**From:** James Kirkham  
**Sent:** 09 March 2022 10:44  
**To:** DC Support  
**Subject:** FW: 21/00922/OUT Land W of Foxden Way, Great Bourton

**From:** Judith Ward <Judith.Ward@Cherwell-DC.gov.uk>  
**Sent:** 07 March 2022 14:23  
**To:** James Kirkham <James.Kirkham@Cherwell-DC.gov.uk>  
**Subject:** 21/00922/OUT Land W of Foxden Way, Great Bourton

Comments made on June 17<sup>th</sup> 2021

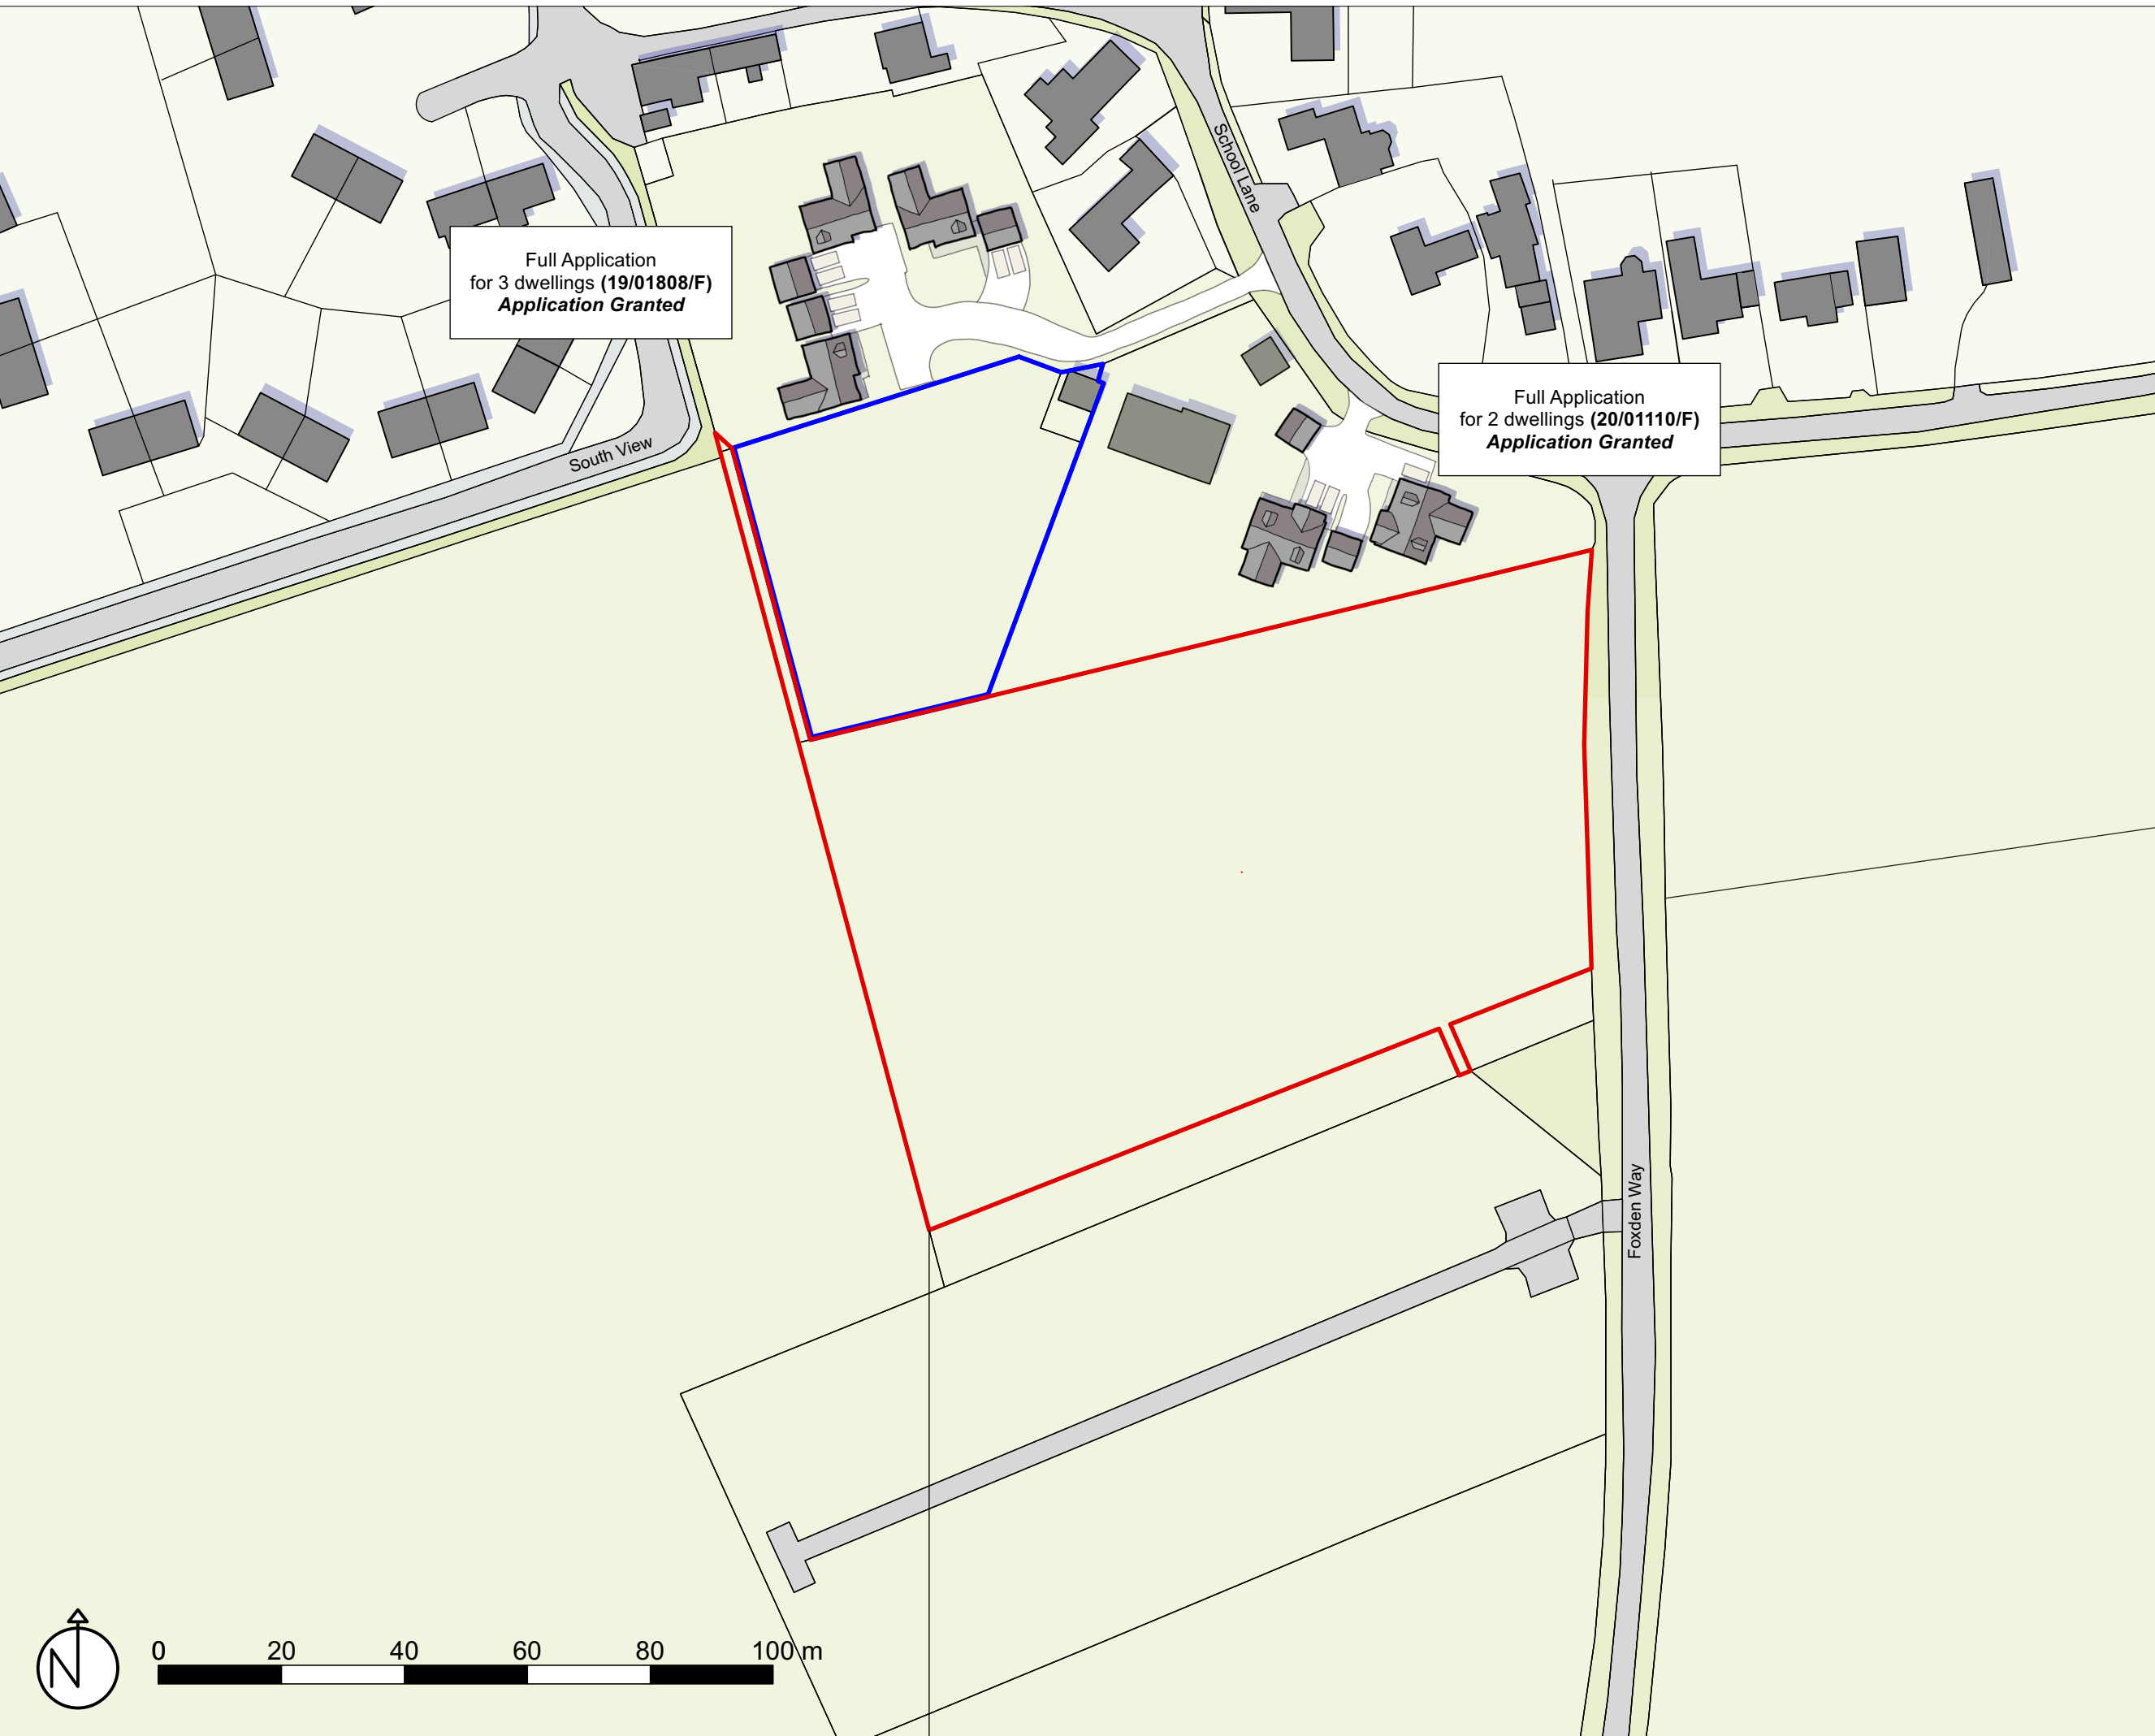
Further to the comments which I made on June 17<sup>th</sup> 2021, which still apply. I would like to add the following: The LVA suggested a layout which provided an 'appropriate and sensitive transition between the proposed development and the wider landscape' 'with a positive outward looking approach to the east, south and west' A layout like this was proposed in the D&A statement but has now been abandoned. The layout submitted allows for further dwellings to the south to be built at a later date. These dwellings will have rear gardens backing onto open countryside which is not a positive outward looking approach. Rear gardens with all their domestic additions do not provide for an attractive or sympathetic rural edge. There is nothing in the D&A statement which gives any indication of the design quality of the scheme.

I object to the proposals on the following grounds: 1. The site is on the periphery of the village and outside the visual boundaries of settlement 2. Hedgerow cover is poor in winter and will result in the proposed development being visible from a number of viewpoints. 3. The layout of the proposal is not in keeping with the village. It is an isolated cluster of dwellings which doesn't bear any relationship to anything. 4. The houses appear to be executive detached dwellings and not affordable housing. There would therefore be no justification for this being a rural exception site 5. There appears to be no analysis of the site and its surroundings carried out and no attempt to locate properties with the existing village form or the landscape. The D&A statement is totally inadequate.
